**Case Officer:** Lewis Knox

**Applicant:** Mr & Mrs P Taylor

**Proposal:** Single/two storey rear extension

P/19/238/001

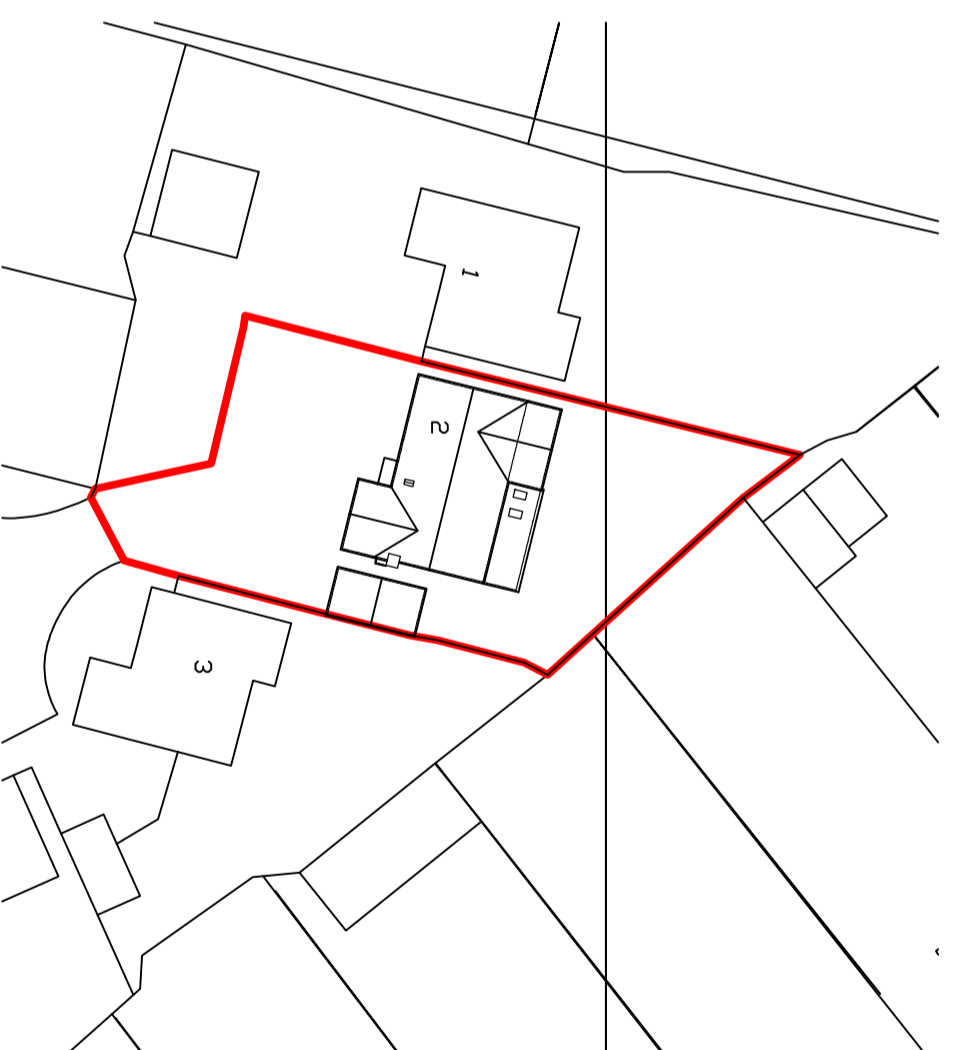
- 8.18. There are trees which are subject to Tree Preservation Orders within the site boundary, and the proposed development would extend towards the TPO trees at the rear of the site. The part of the proposed extension which would be closest to these trees is the single storey element to the eastern side. As this element of the extension would not extend as deep as the existing conservatory on this part of the site, it is considered that there would be less impact on the TPO'd trees than the current situation and is considered acceptable in this respect.

PROPOSED REAR NORTH ELEVATION

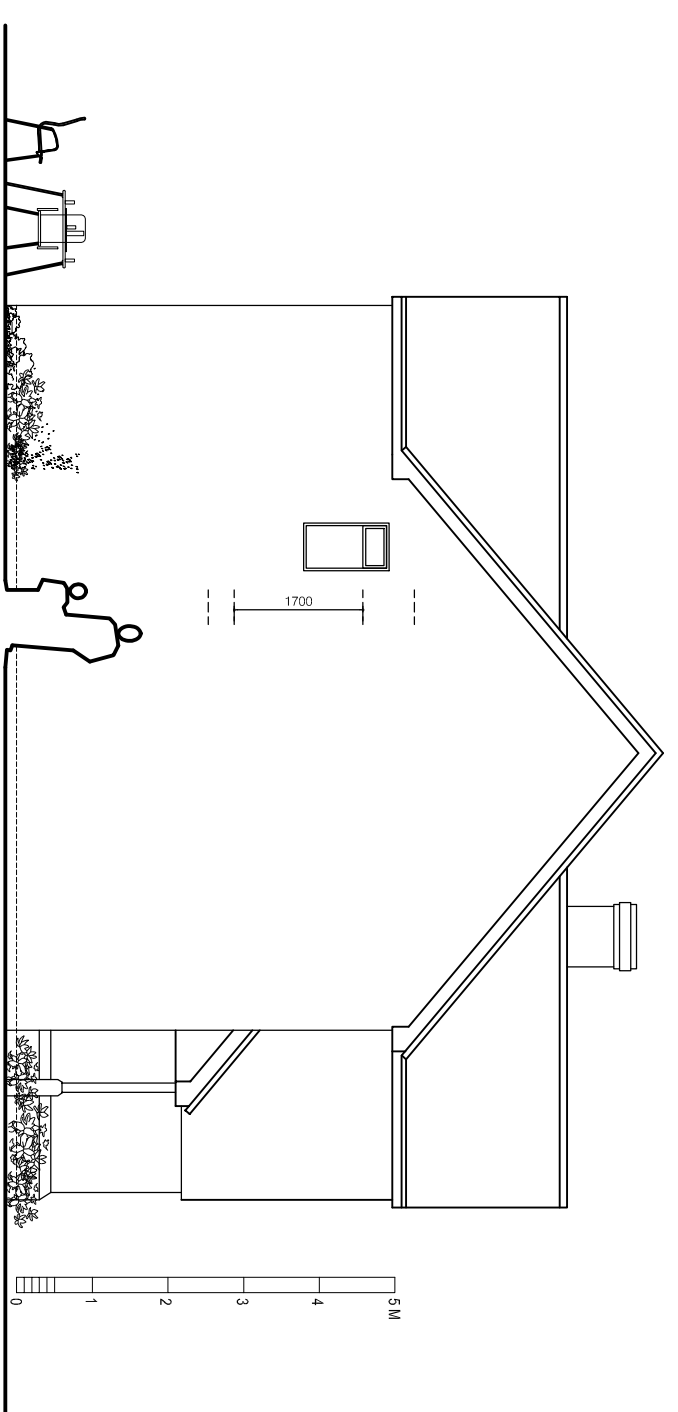
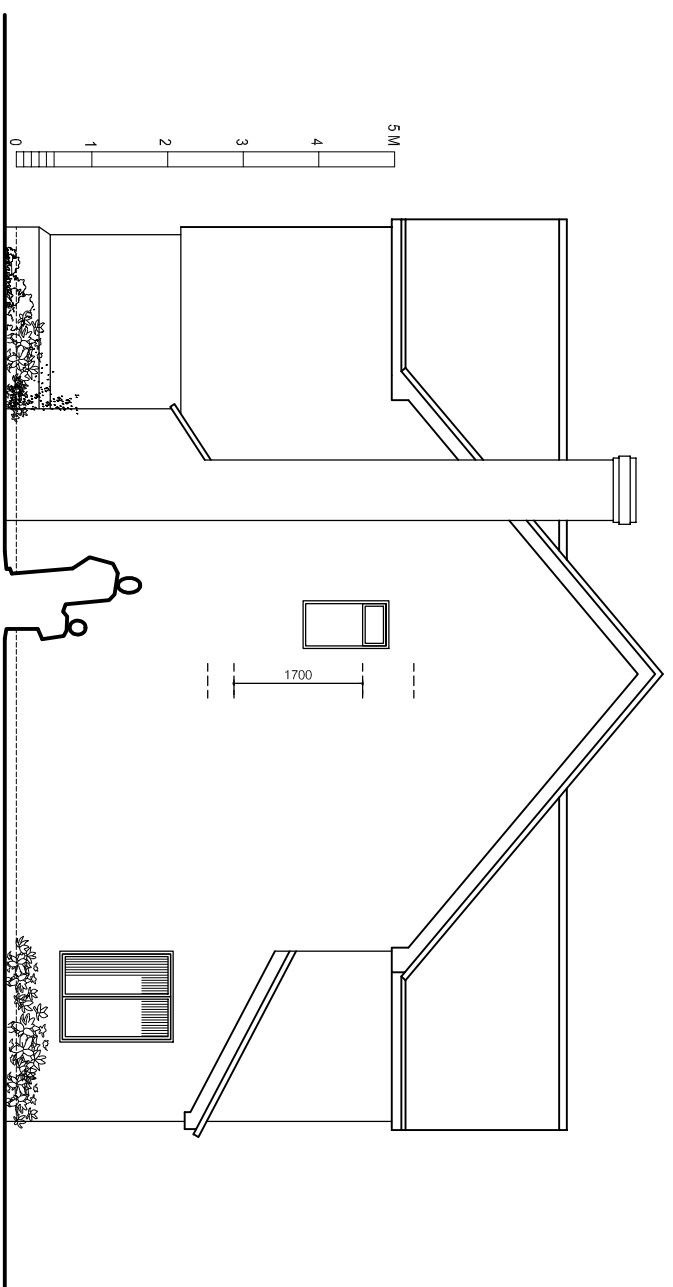
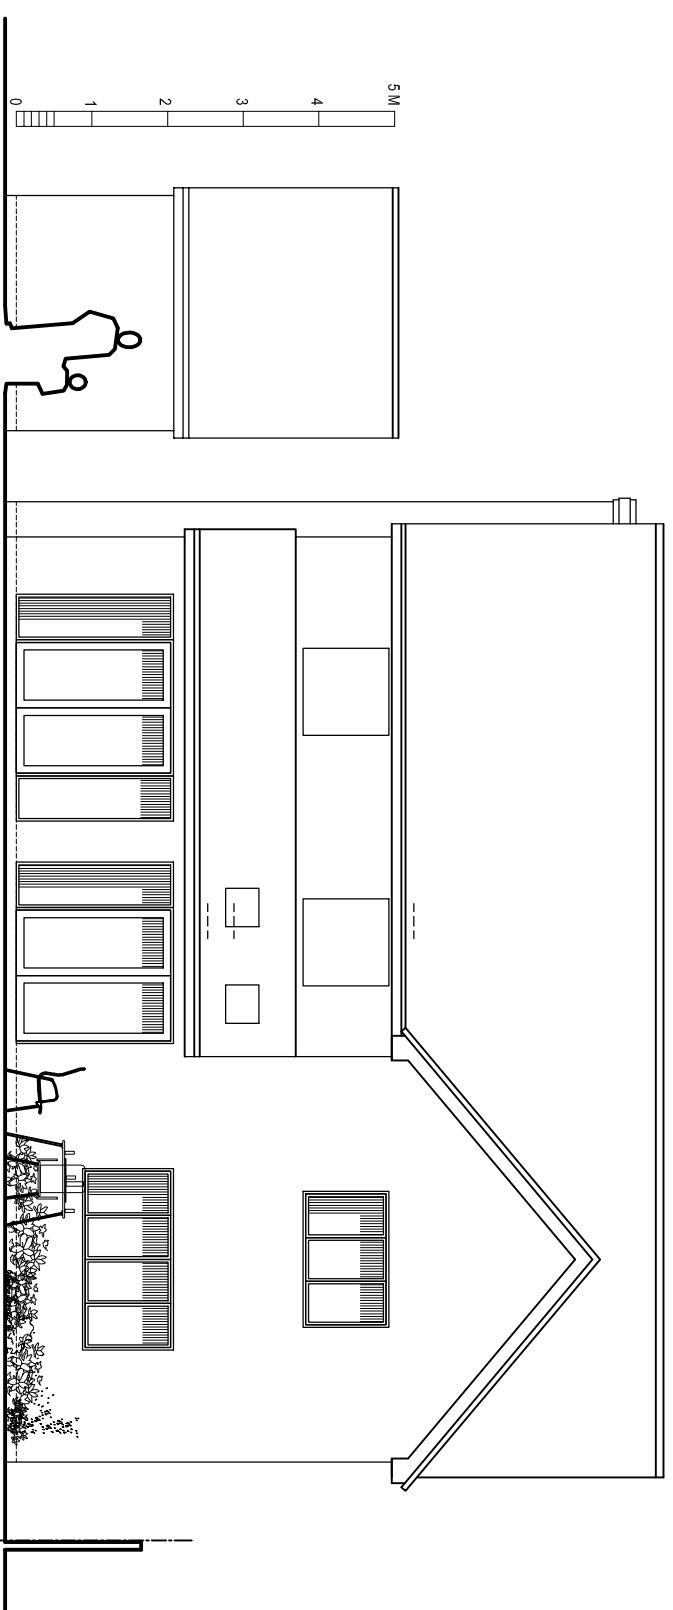
- 8.5. The majority of the other neighbouring dwellings which were built as part of this residential development we constructed with a projecting gable to the rear elevations. The application dwelling does not currently benefit from this design. The proposed extension would see a two storey gable end to the western side of the rear elevation which would mirror the neighbouring dwelling. It is considered that this element would continue the established character which is set in the locality.

- 8.14. The majority of newly proposed openings would face towards the rear of the garden at the site and would not directly face any opening to a nearby neighbour and would therefore not impact on the levels of privacy in the locality. There is one side window on the eastern elevation but this would not directly face the neighbouring dwelling to this side and would have a similar impact on privacy as the existing conservatory and so there would be no impact beyond the existing situation.

PROPOSED GROUND FLOOR PLAN

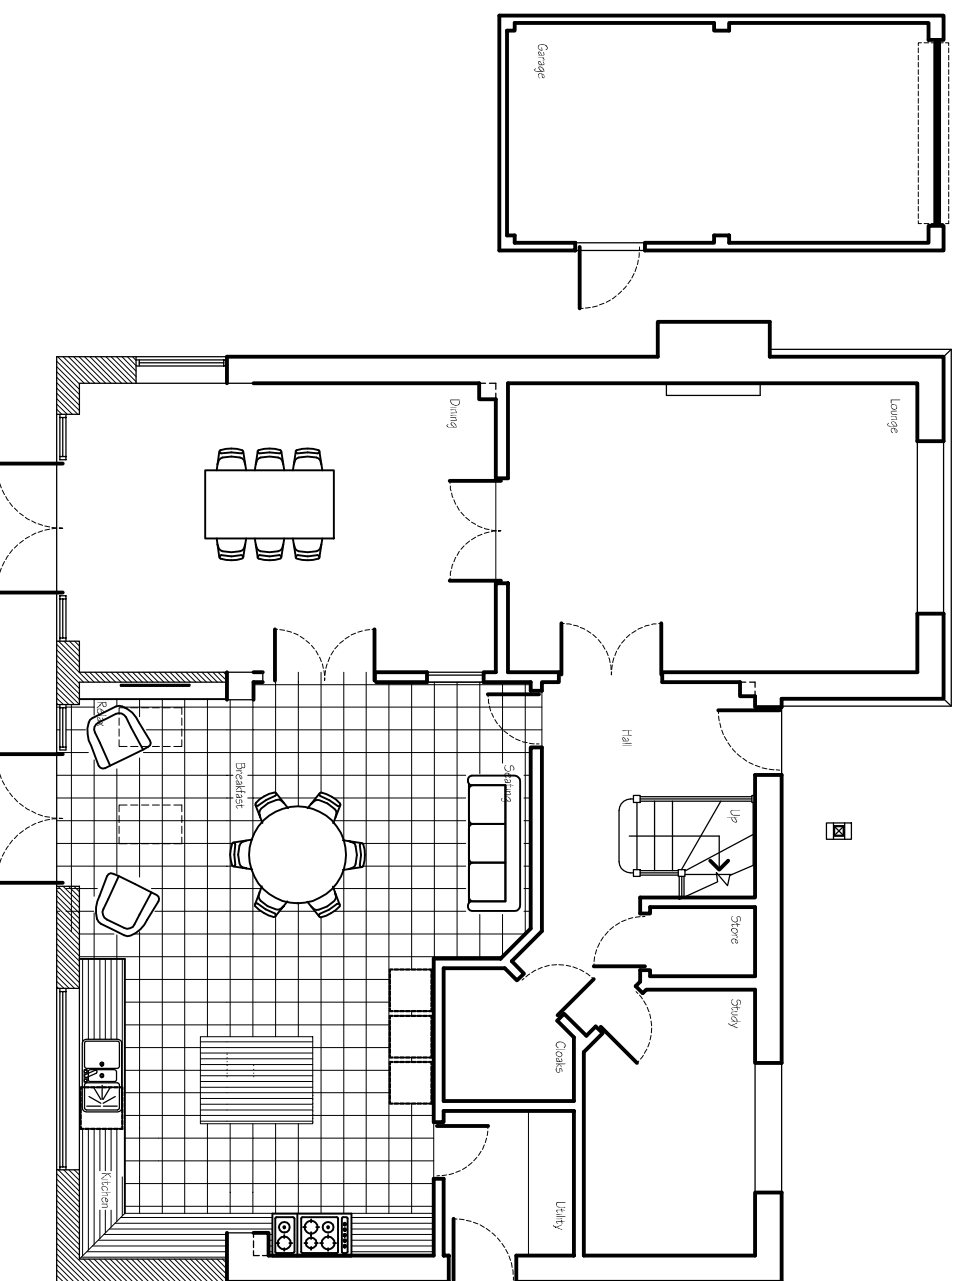
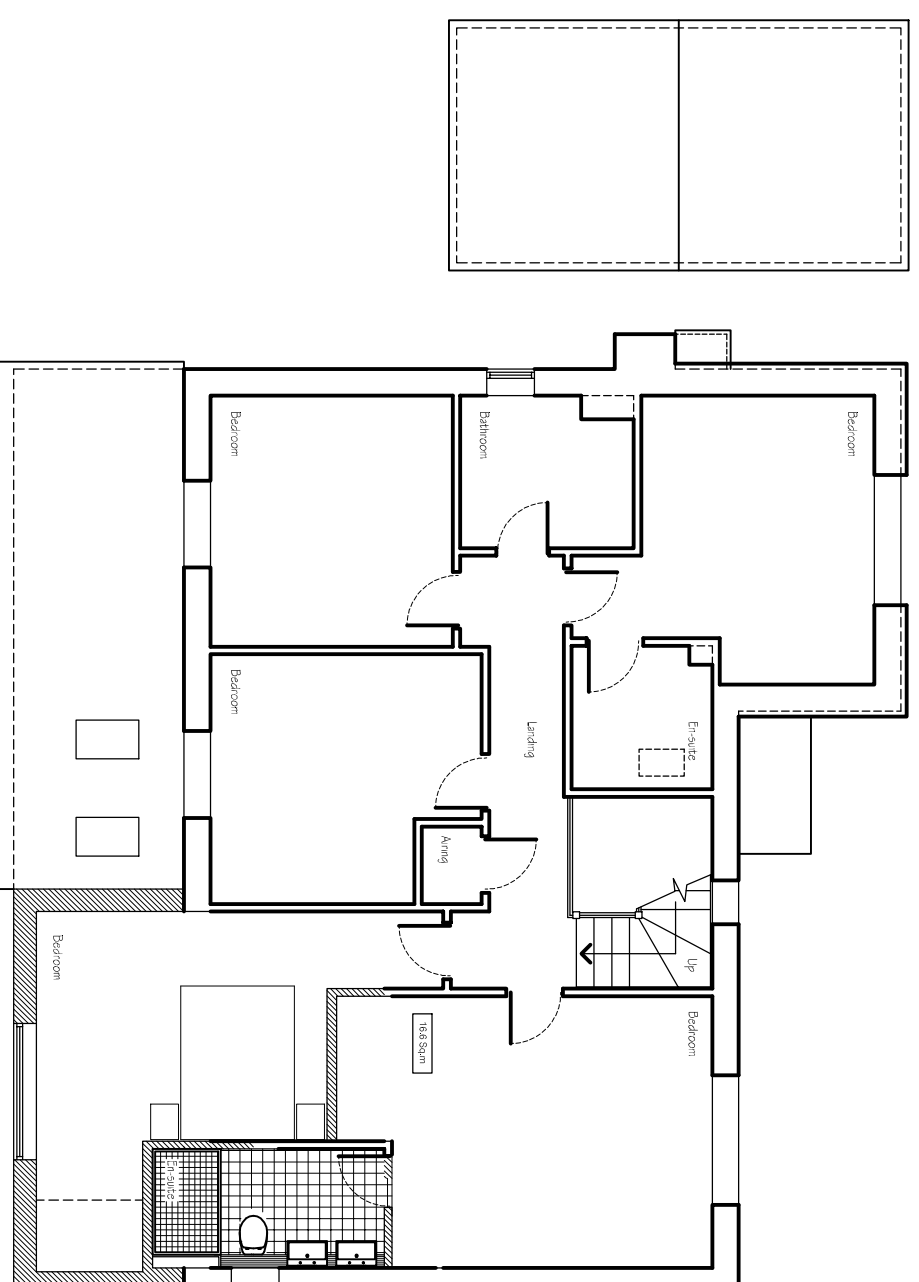
- 8.12. The proposed two storey element would match the height of the application dwelling but would only have a minor depth of approximately 2.25m and would not extend beyond the rear gable projection on the neighbouring property. It is therefore considered that the development would not conflict with the 45 degree rule from the nearest neighbouring habitable window and would therefore not impact on the amenity of the neighbouring occupants in terms of loss of light, loss of outlook or overbearing.

- 8.13. The proposed single storey element would have the same depth and would not be in close proximity to any near neighbour and as such would not impact on the amenity in terms of loss of light, loss of outlook or overbearing.
